RE: 1321 Flightway Ave SE
Grading and Drainage Plan
Engineer's Stamp Date: 03/10/2026
Hydrology File: M15D056A
Case # HYDR-2026-00090

Based upon the information provided in your submittal received 03/10/2026, the Grading and Drainage Plan **is not approved** for Grading Permit and Building Permit. The following comments need to be addressed for approval of the above referenced project.

**GD-2**

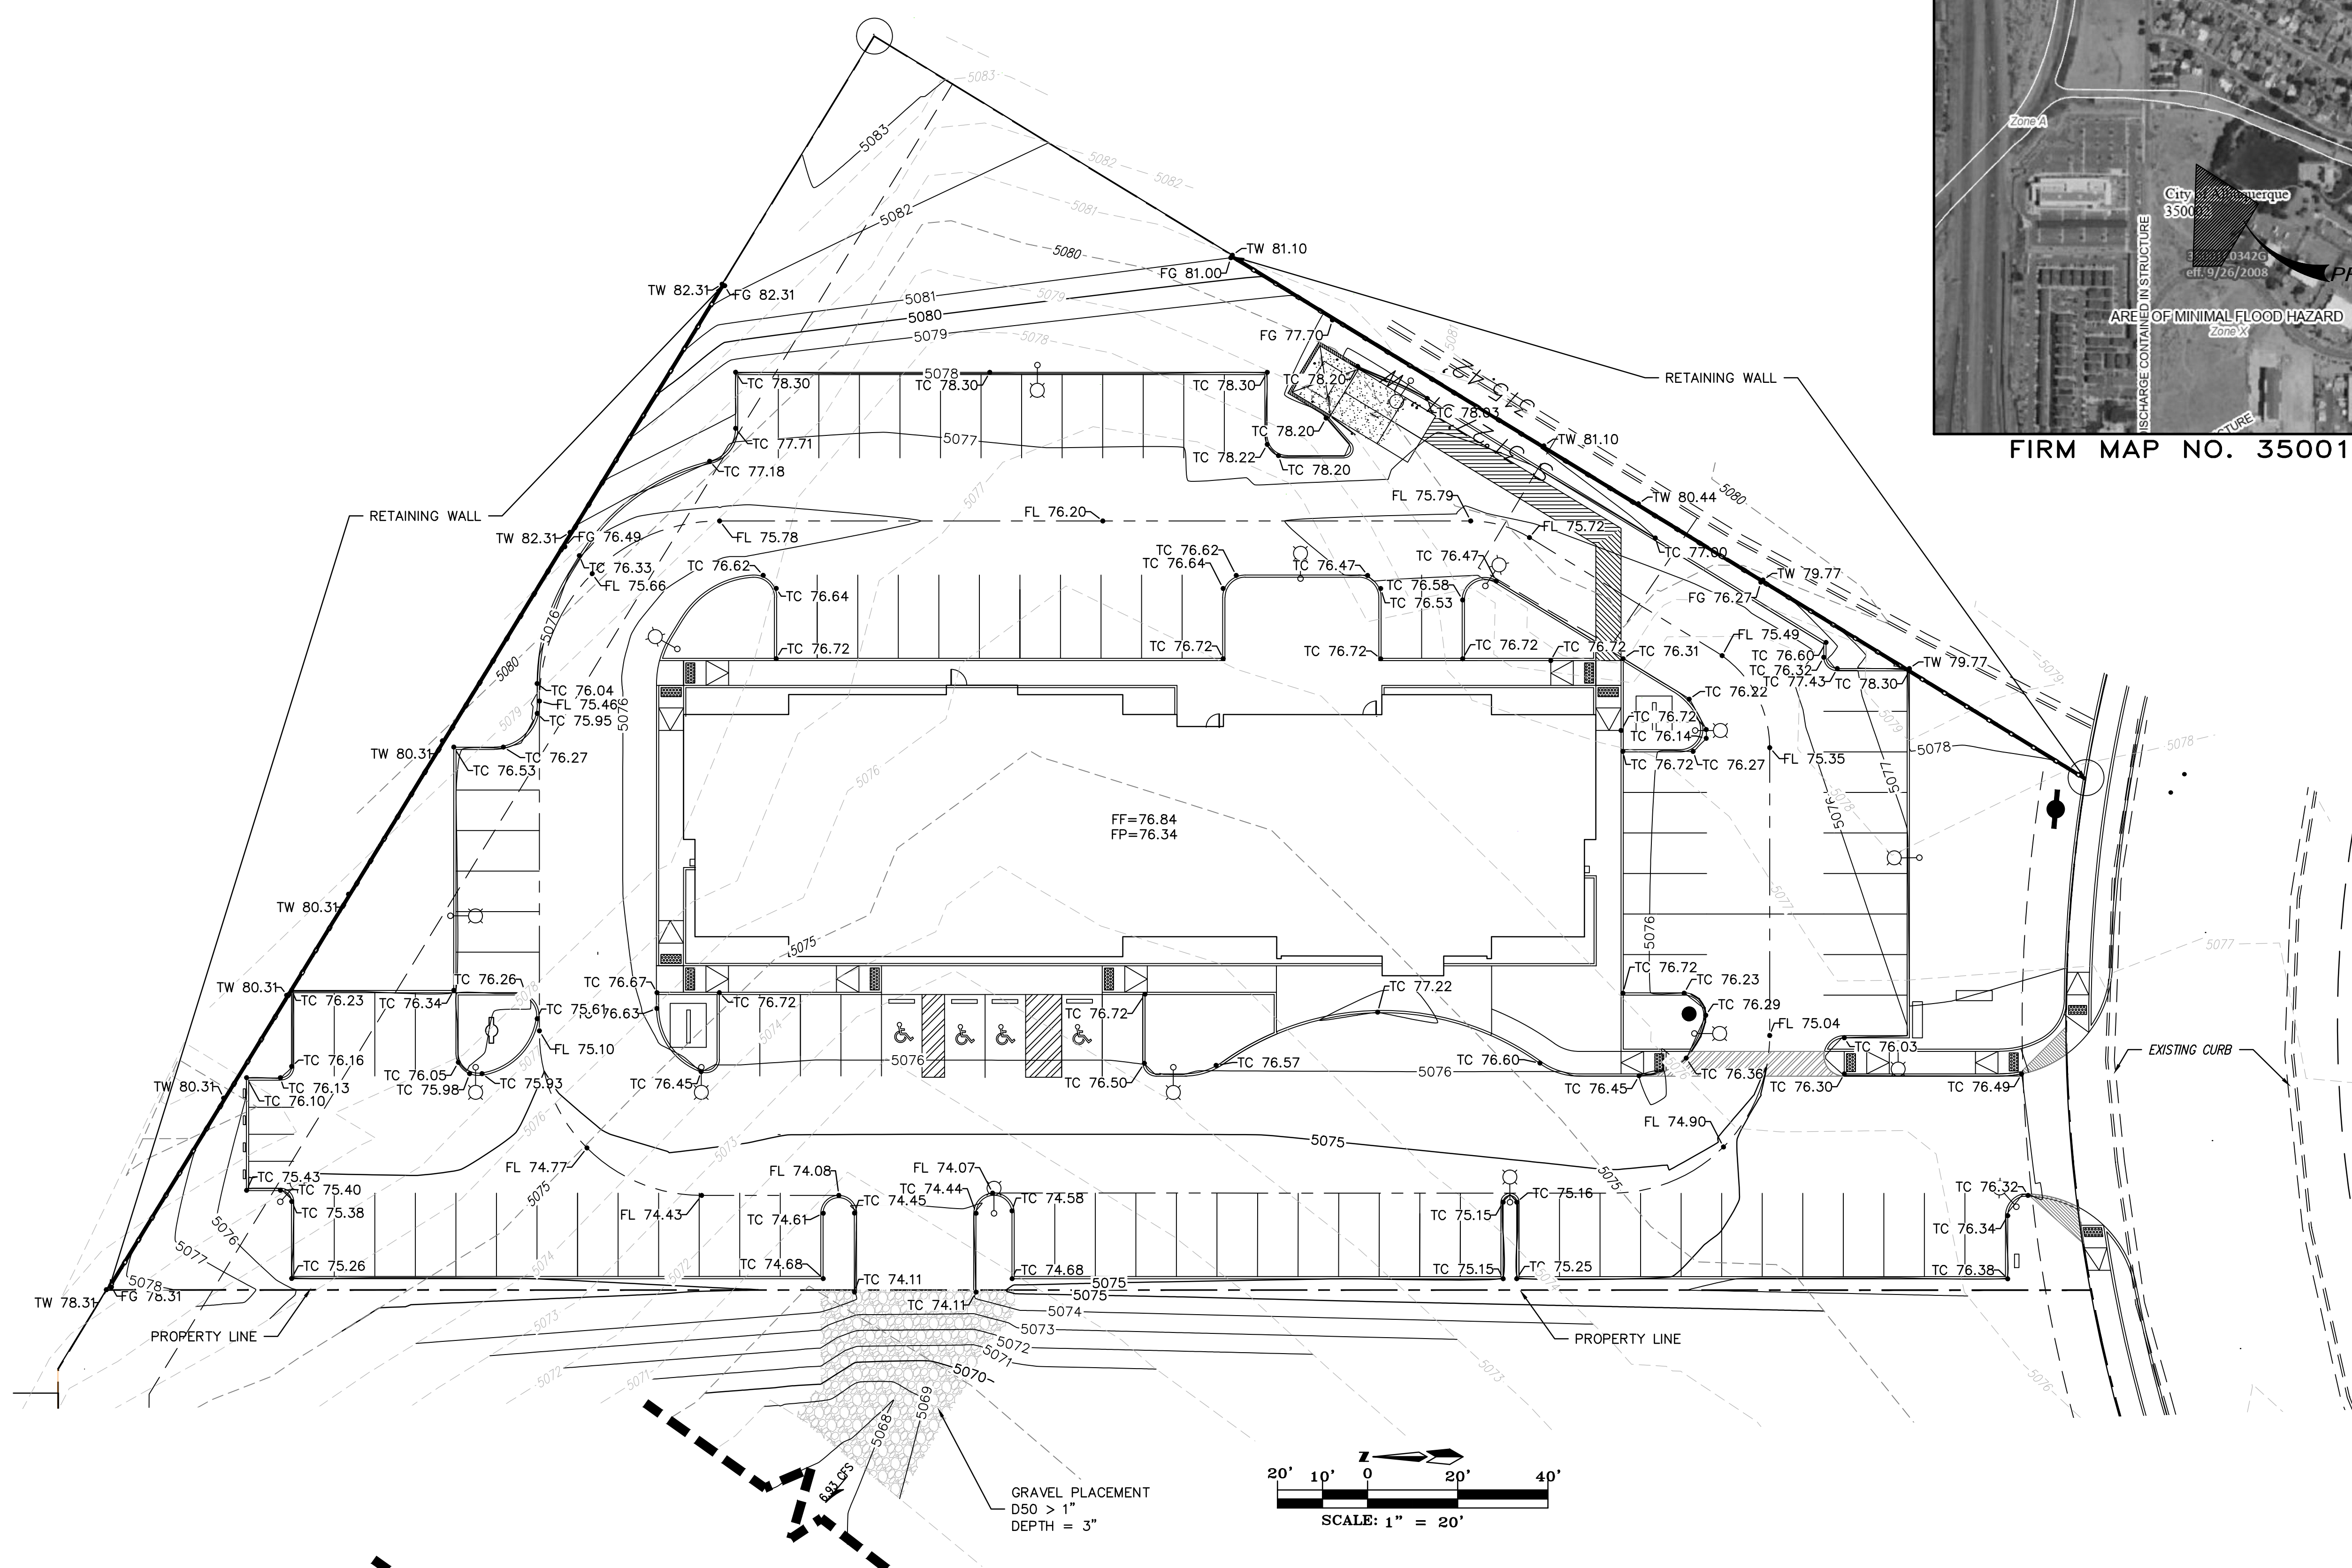
2. Per the IDO, the property owner of the property is responsible for building the adjacent half of Flightway Ave to include curb & gutter, and sidewalk. The project will have to go to the Development Facilitation Team (DFT) for approval of the Infrastructure List.
3. Include project benchmark and datum.
4. Add to General Notes #4 (Both Sheets) - "Side slopes need to be stabilized with Native Grass Seed (per City Spec 1012) with Aggregate Mulch or equal (Must satisfy the "Final Stabilization criteria" CGP 2.2.14.b.)".
5. Please number the ponds and include a label on each with the SWQV and elevation, the 100-year volume and elevation, the peak 100 year inflow and outflow, the spillway crest elevation, the spillway flow depth, and the dam top elevation.

**GD-1**

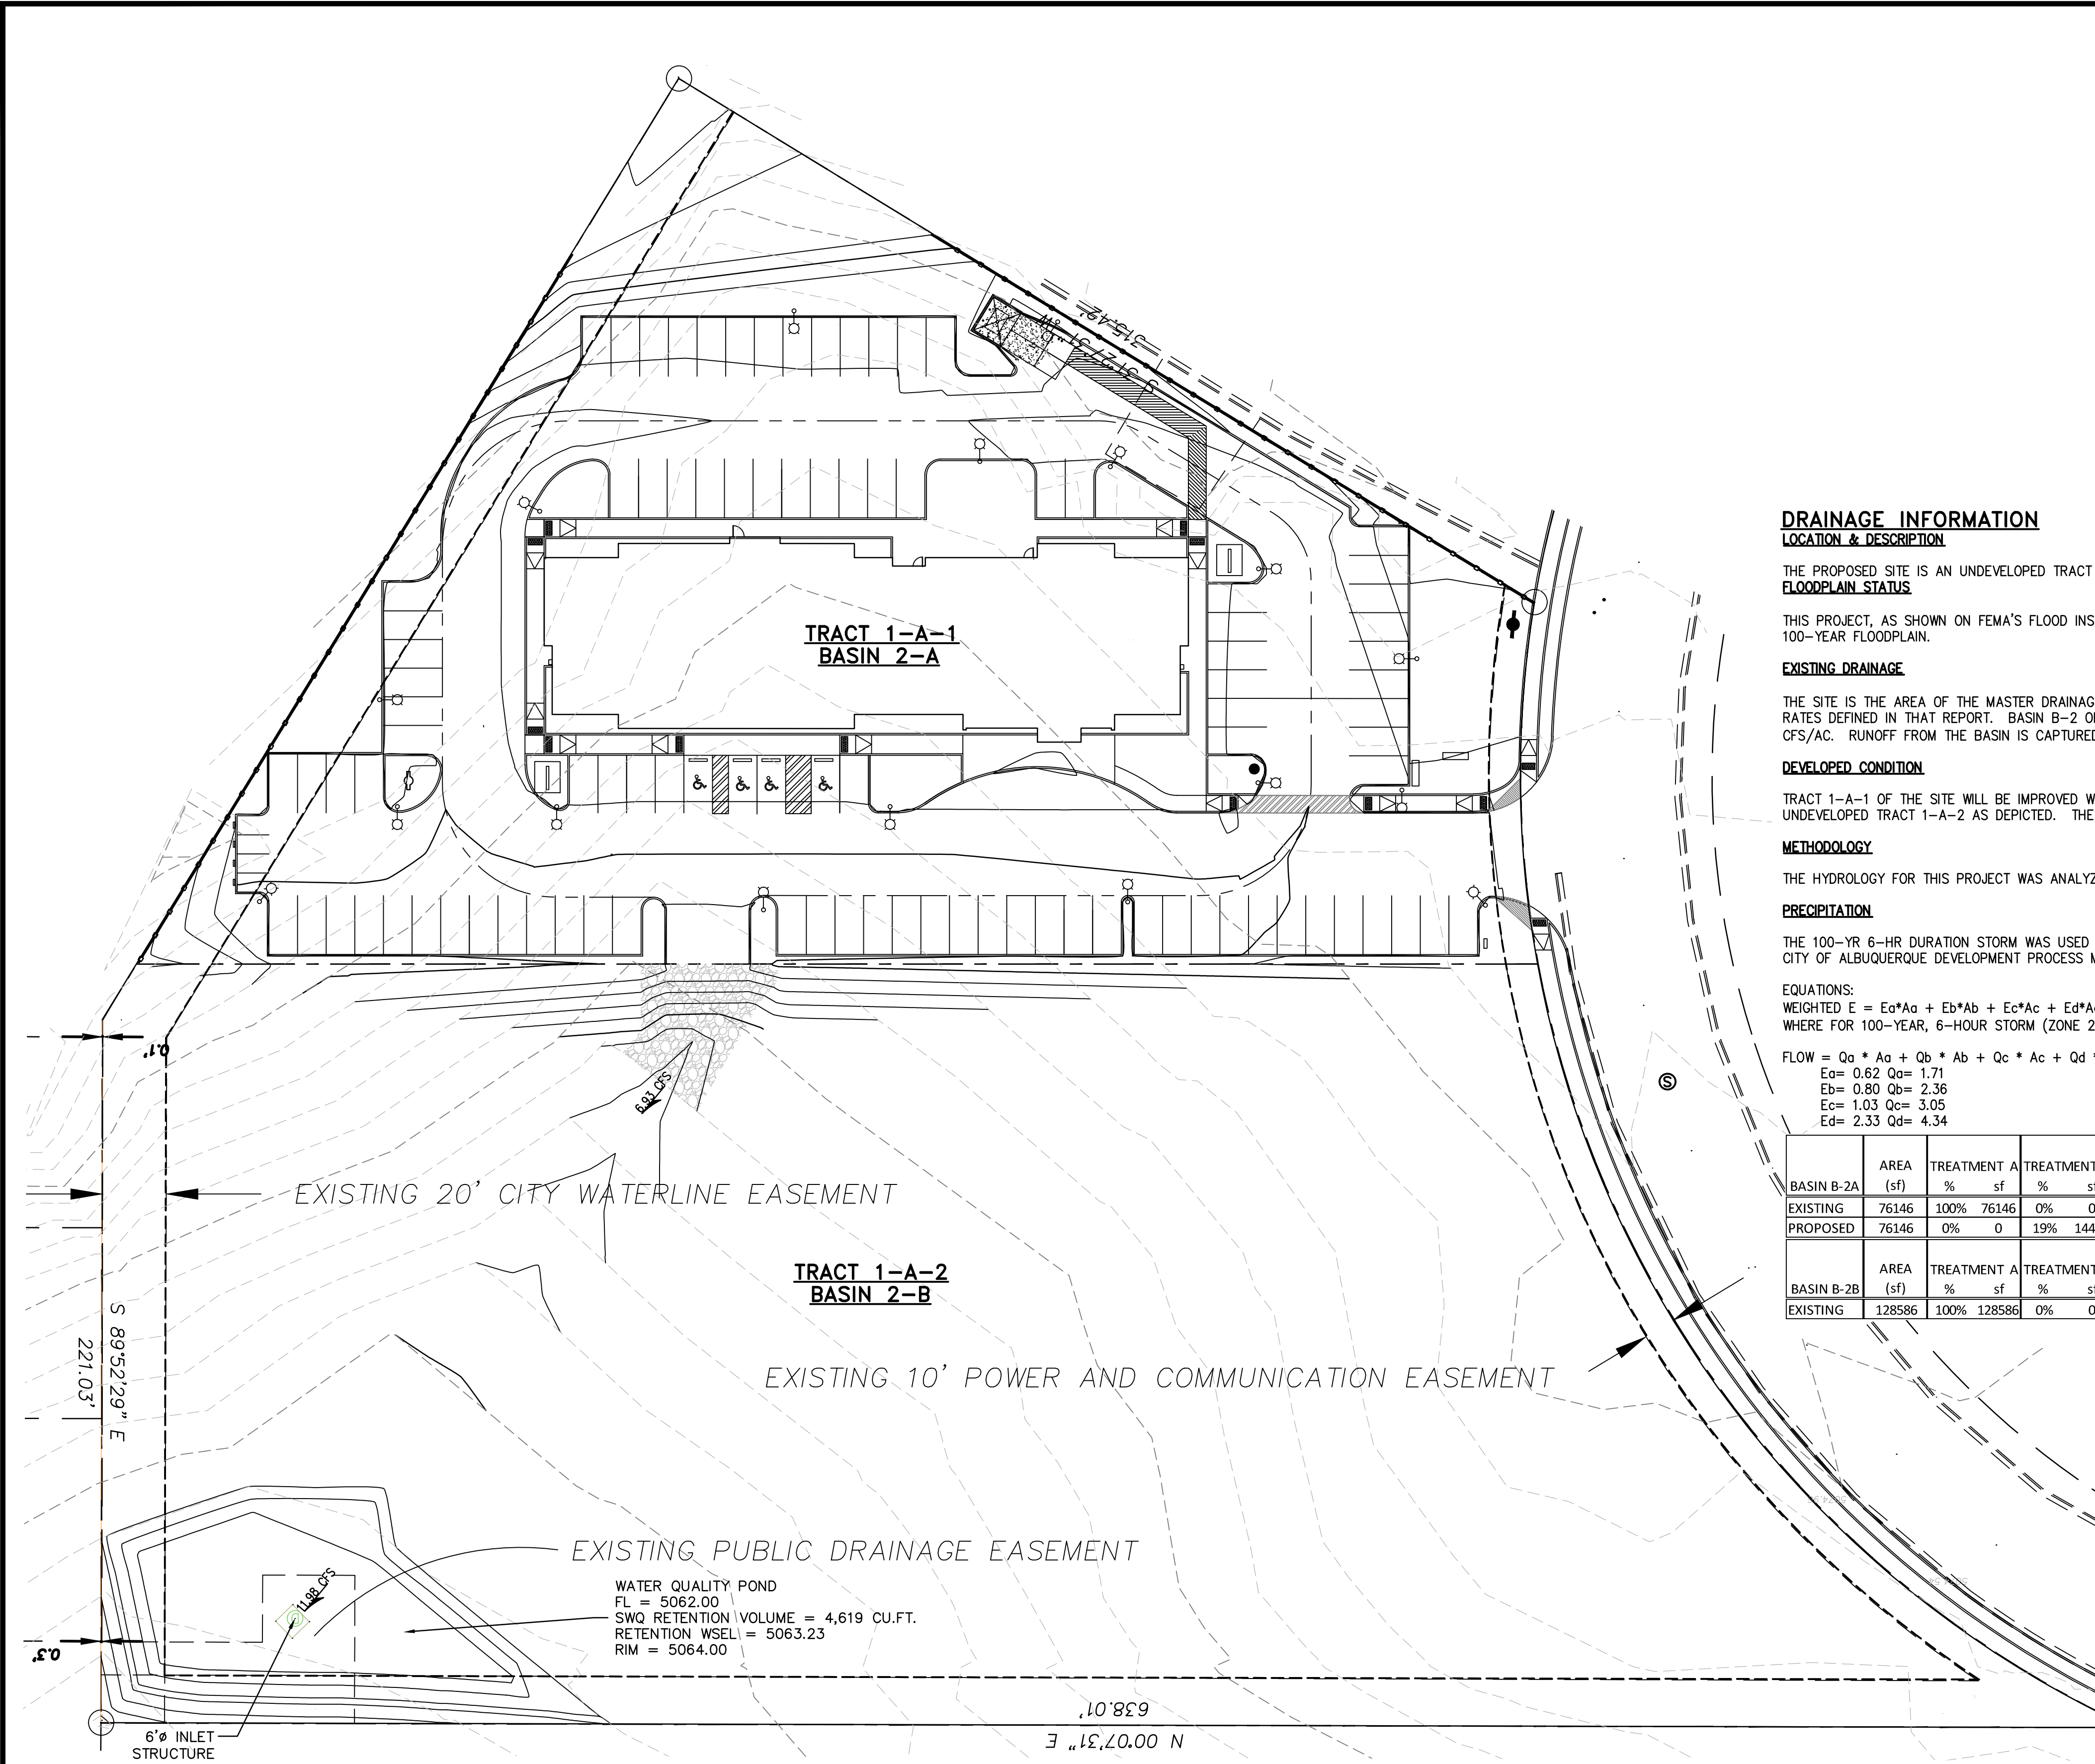
1. Show Finished Pad Elevation.
